Rampion Two Offshore Wind Farm

**Appendix E3 to the Natural England Deadline 3 Submission**

**Natural England's Advice on the Applicant's Deadline 1 submissions relating  
to Fish and Shellfish**

Planning Inspectorate Reference EN010117

Figure 2-1 Marine Conservation Zones (MCZs) in relation to the Rampion 2 proposed DCO Order Limits

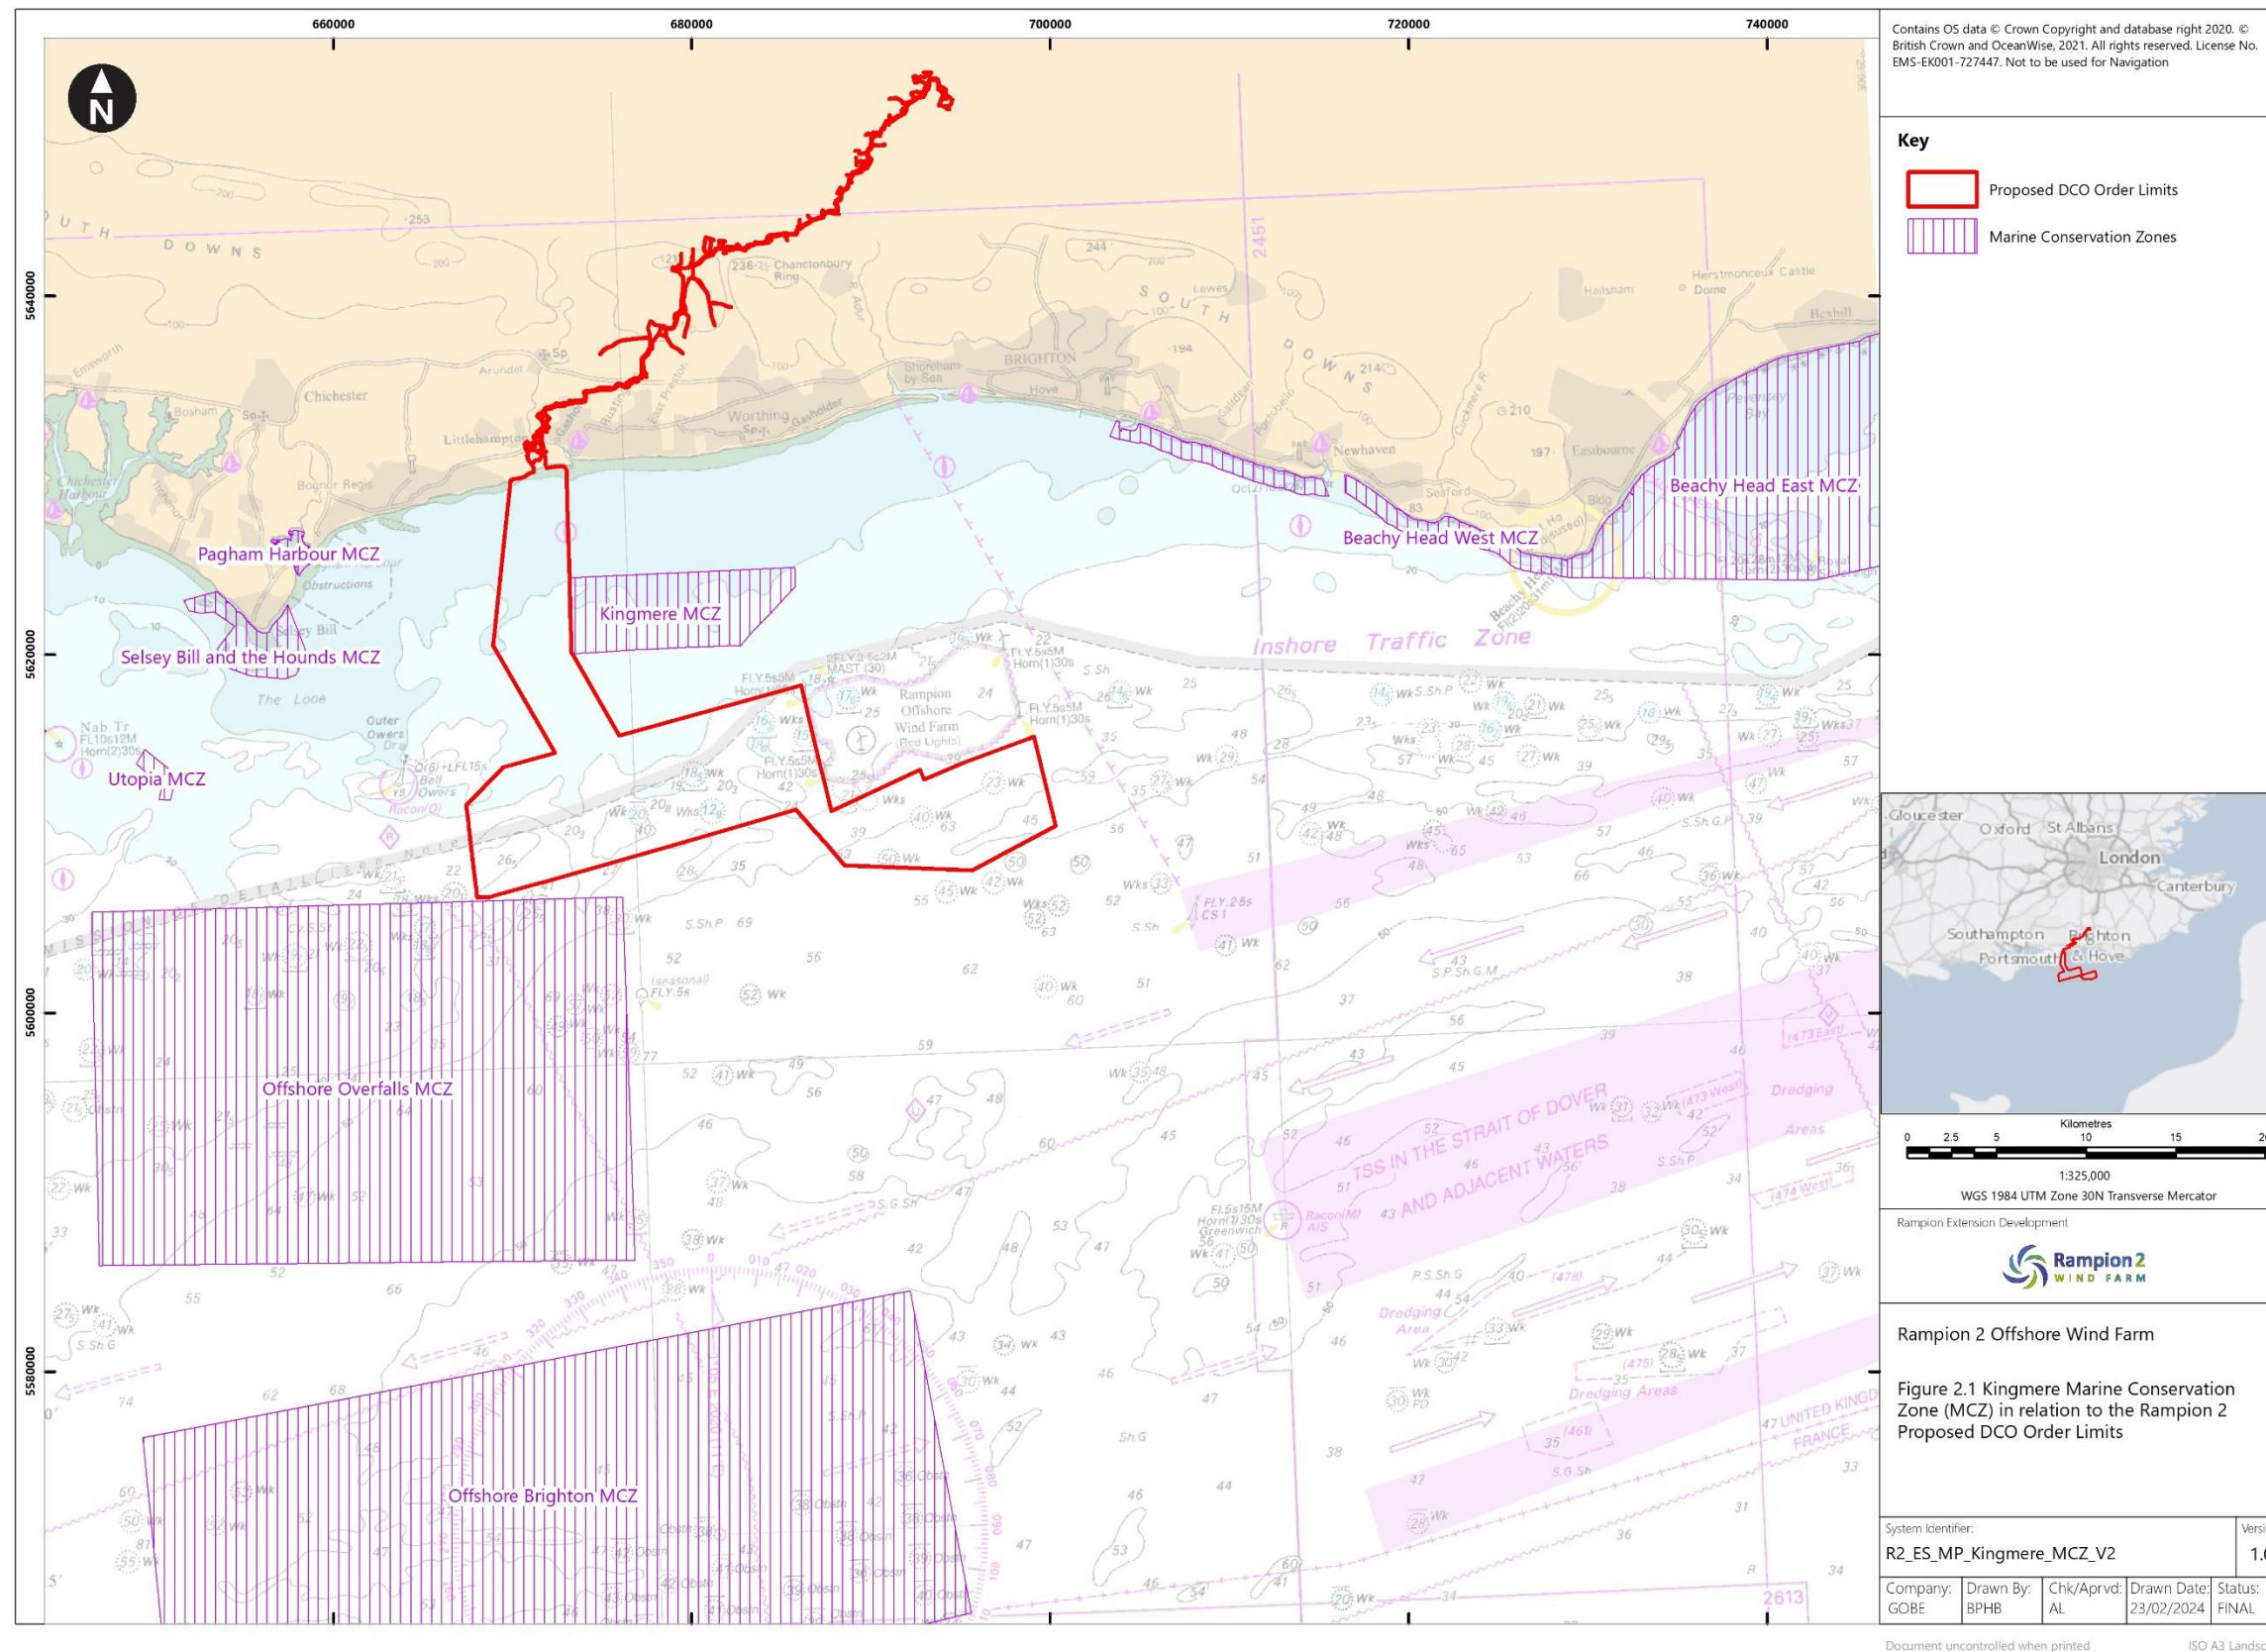
The revision log suggests the only changes to [REP1-012] are updates to Figures 2.1 and 5.1. As described in the Applicants Responses to Relevant Representations [REP1-017] the change to Figure 5.1 involves increasing the resolution and the change to Figure 2.1 involves ensuring all MCZs are shown. Therefore, aside from addressing our comment on Figure 2.1, our advice on this document remains the same as stated in our Relevant Representations.
